**Consultation Response from KC,
Trees**
2020/93047 2, Netherfield Close, Kirkburton, Huddersfield, HD8 0UR
Erection of ground and first floor extensions
Date Responded:28/10/20
Responding Officer:JR
Responding Ref: TPO 07/89

Site Plan

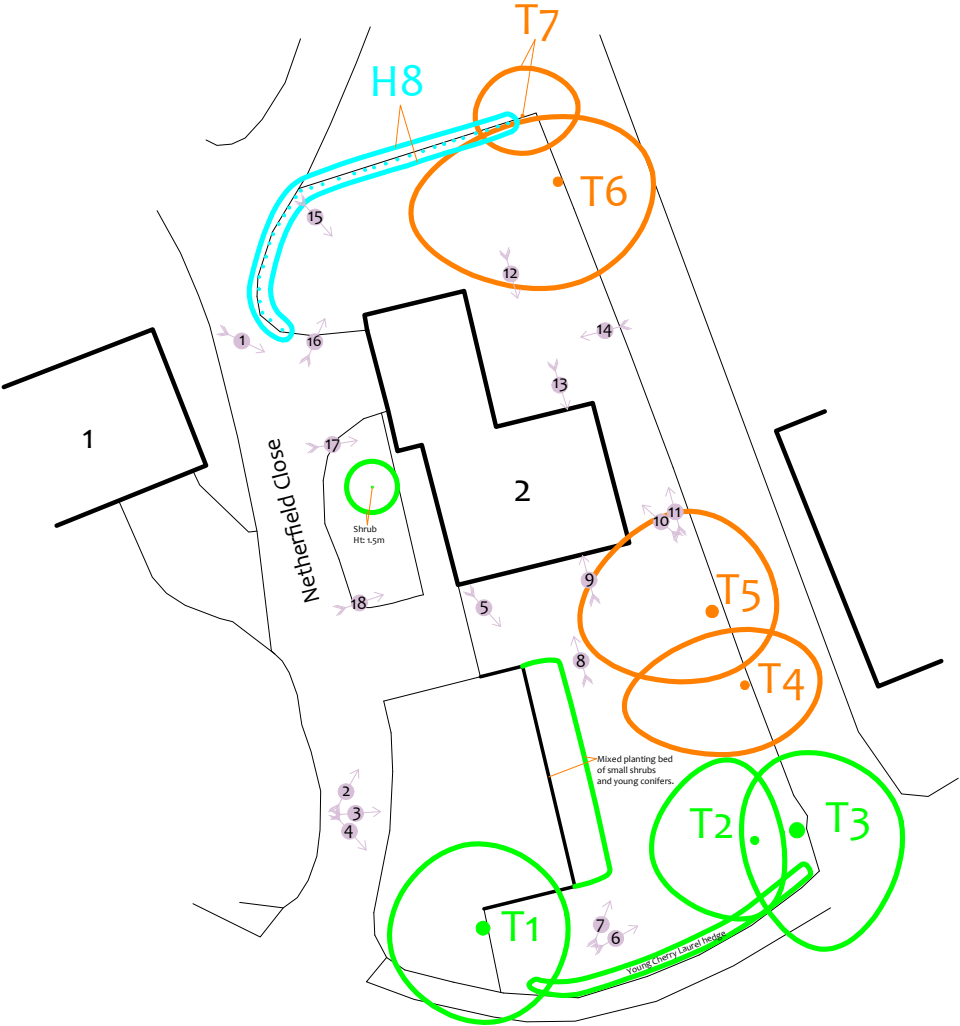
The tree document provided in support of this application is not an arboricultural impact assessment or method statement . However, that said, it does provide sufficient basic survey information to show that the proposed extension will not directly impact on the adjacent protected tree (T70 of TPO 07/89).

Although, given the proximity or proposed construction works to the likely root protection area of a mature tree, we will need to see tree protection measures put in place during the construction phase, via an arboricultural method statement. Ideally this should be secured pre determination or, if required, by a pre commencement condition. Suggested wording below:

Notwithstanding the submitted plans and information, an Arboricultural Method Statement, in accordance with British Standard BS 5837, shall be submitted and approved in writing by the Local Planning Authority before development commences. The method statement shall include details on how the construction work will be undertaken with minimal damage to the adjacent protected trees and their roots. Thereafter, the development shall be carried out in complete accordance with the Arboricultural Method Statement.
